From: Laura Gibbons
Sent: 27 July 2021 12:12
To: Maria Tomalova
Subject: RE: Y/88/21/DOC

Subject: FW: Y/88/21/DOC

Condition 5

Condition 6

SITE LAYOUT
(1:200)

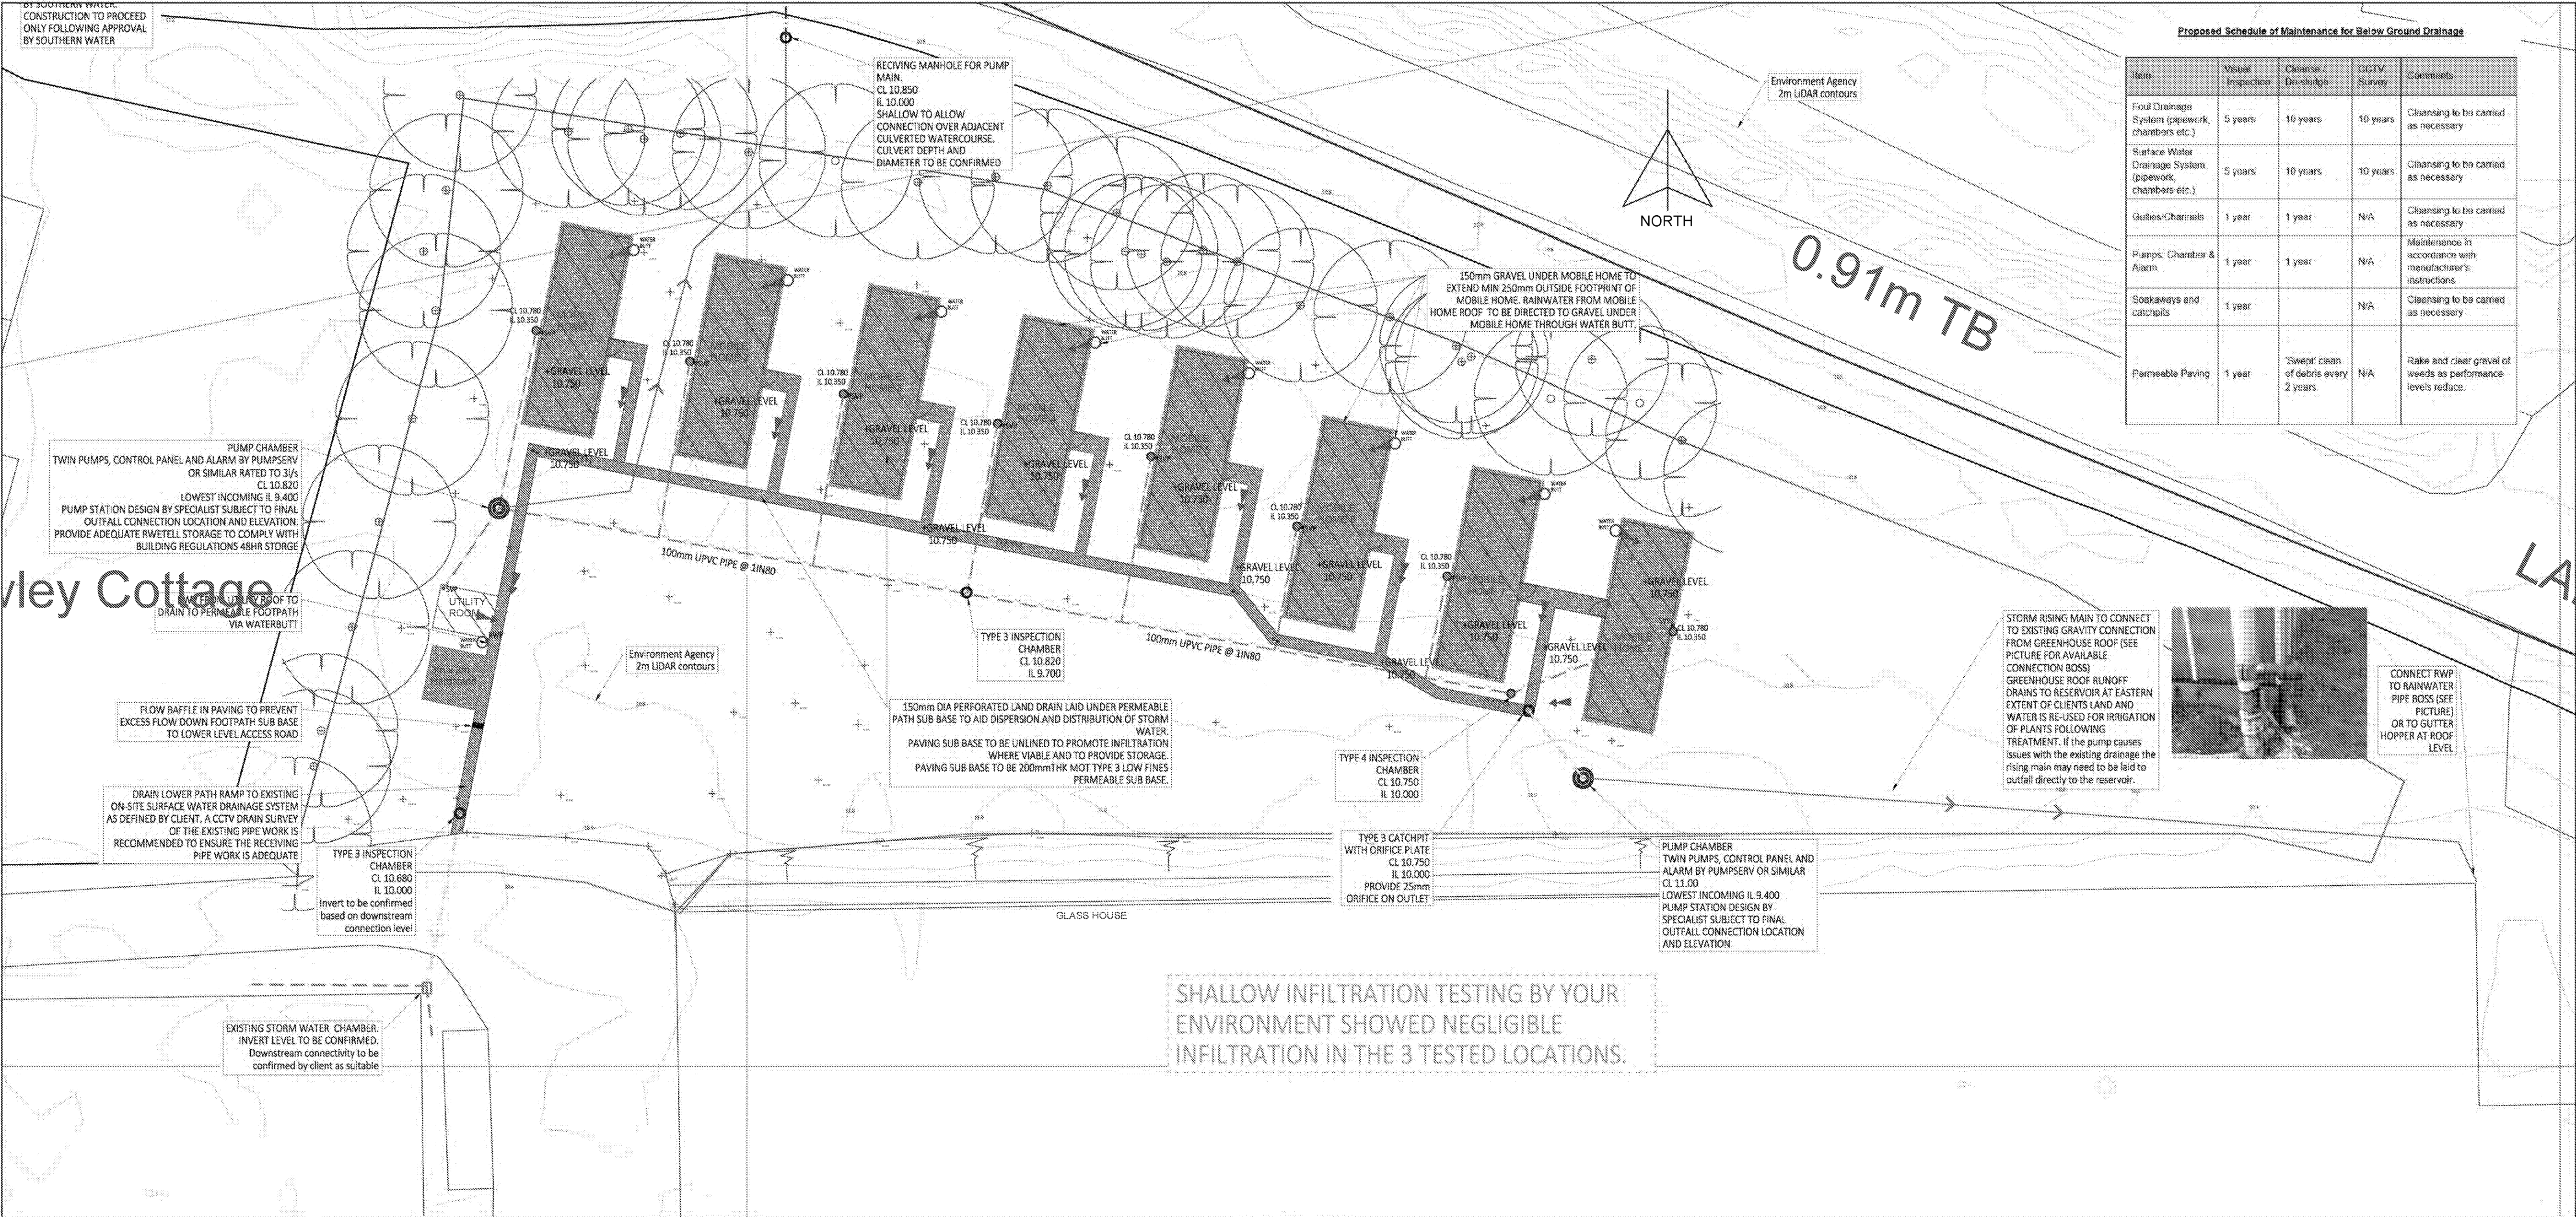
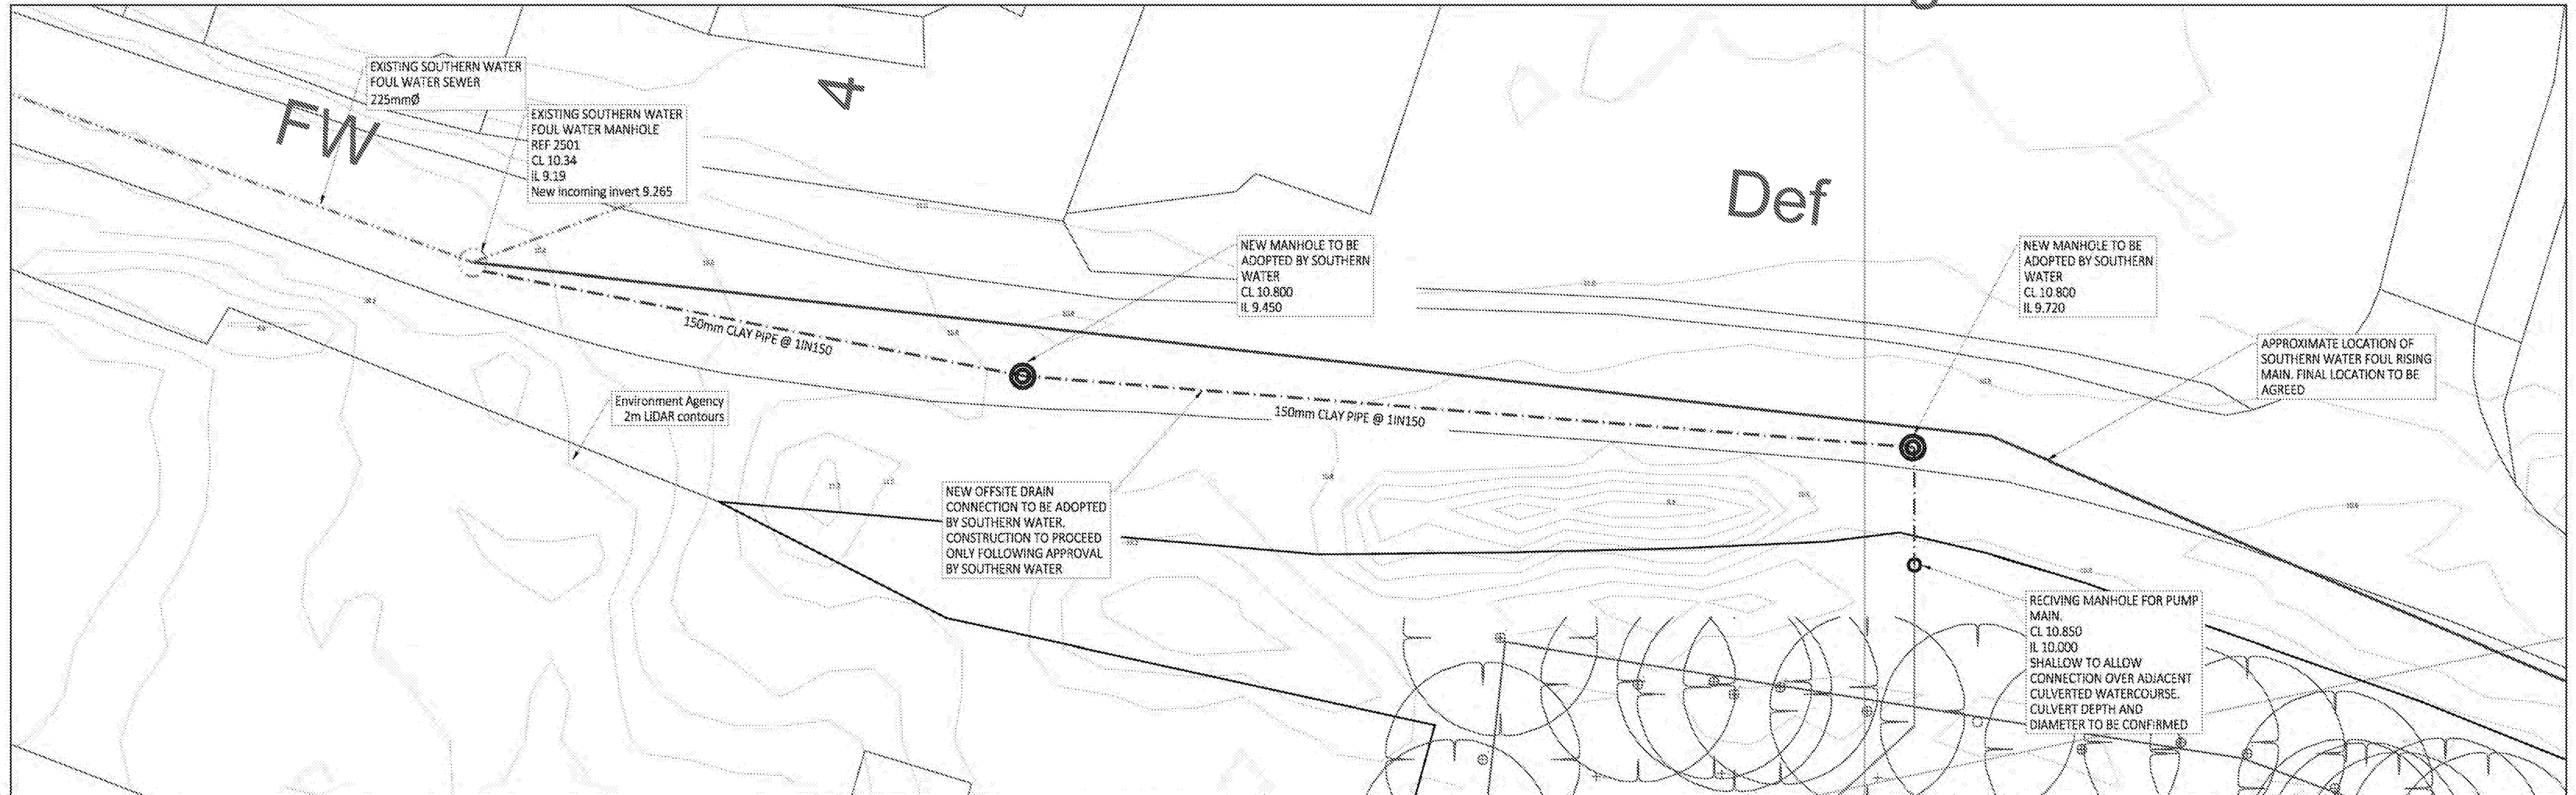
1. The applicant has completed summer infiltration testing which indicate infiltration is not viable.
2. No winter groundwater monitoring results have been provided, this information must be supplied to evidence that groundwater will not get into the surface water drainage system.

3. The proposal is for an unlined system to be pumped. This could in winter result in groundwater being pumped.
4. Pumping is not supported, it is not a sustainable solution. Pumps also fail and can result in increased flood risk both on and off site. The applicant must submit a revised gravity scheme.

5. The proposals are to pump surface water to the on site reservoir. The statement claims that no surface water will be discharged off site. No evidence has been submitted to evidence that either the existing surface water drainage network or reservoir have the capacity to accept these additional flows. The reservoir must also have an overflow to somewhere for water to be discharged in times of exceptional rainfall when irrigation demands are less, i.e. the winter. Therefore the statements provided are not supported by ourselves.

It is not possible for us to recommend discharge of this condition at this time with the strategy presented. A fully revised surface water drainage design is required, which may involve a gravity outfall to watercourse.

APPENDIX C: Soakaway Test Results

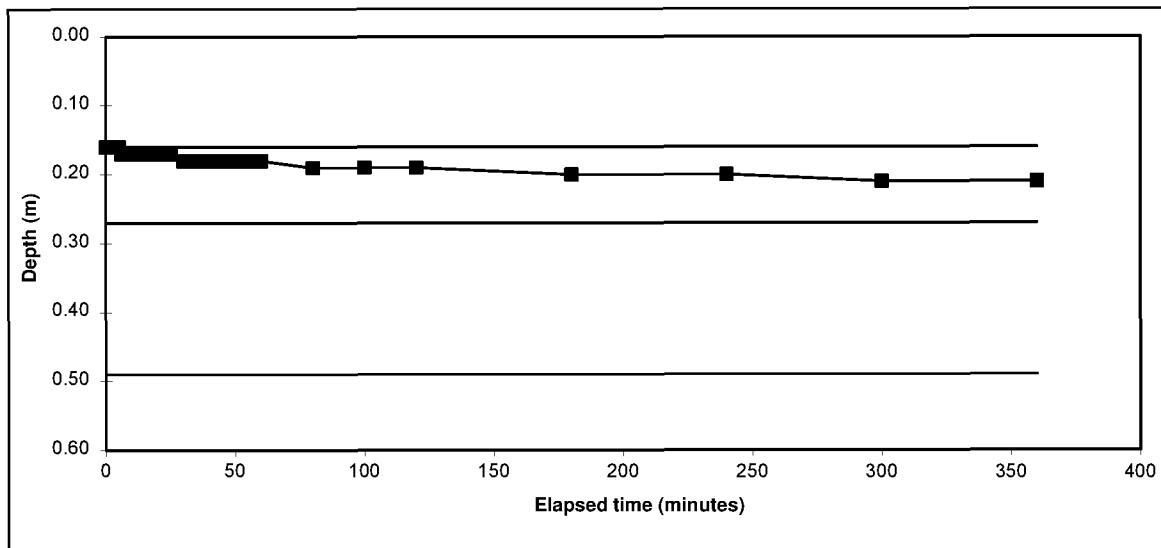
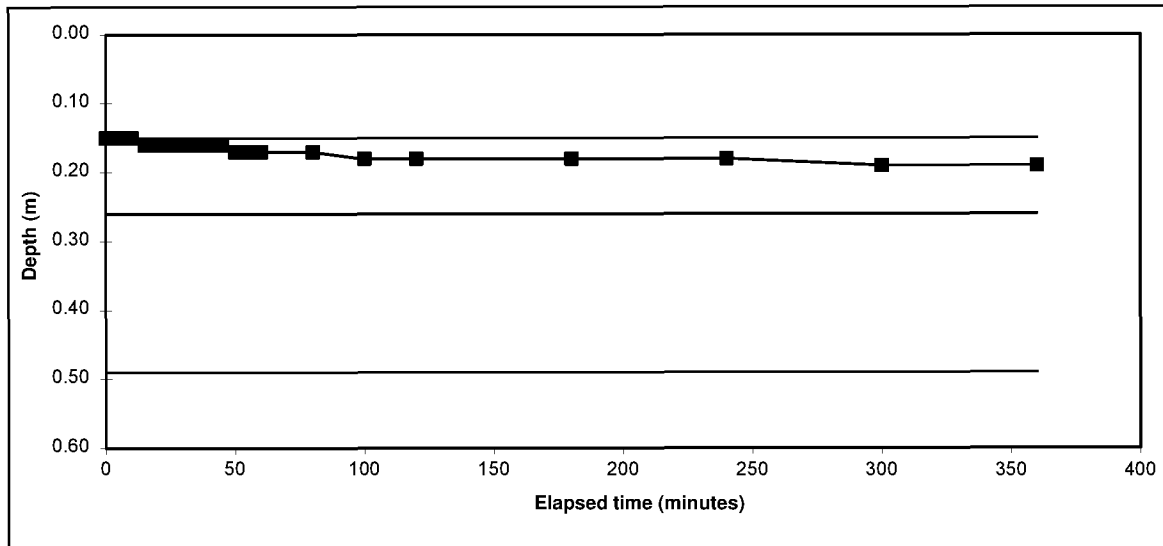
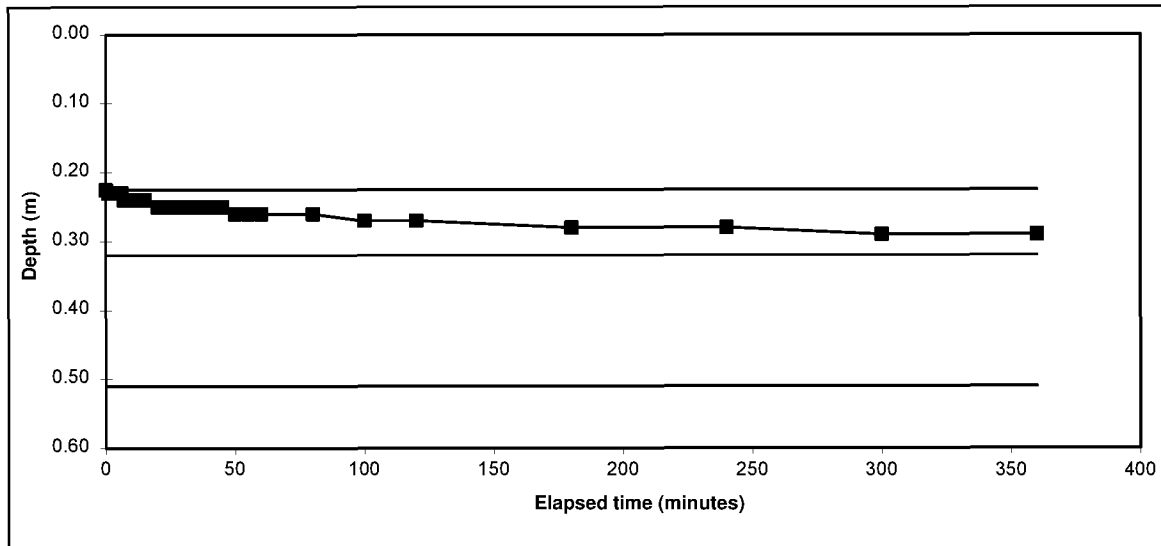
Thanks for sending this over. The information provided is not winter groundwater monitoring results. The applicant has now supplied winter infiltration testing results, however it can be seen that these were completed below groundwater level. The applicant should note that, as per our guidance, groundwater observations on one day do not constitute groundwater monitoring.
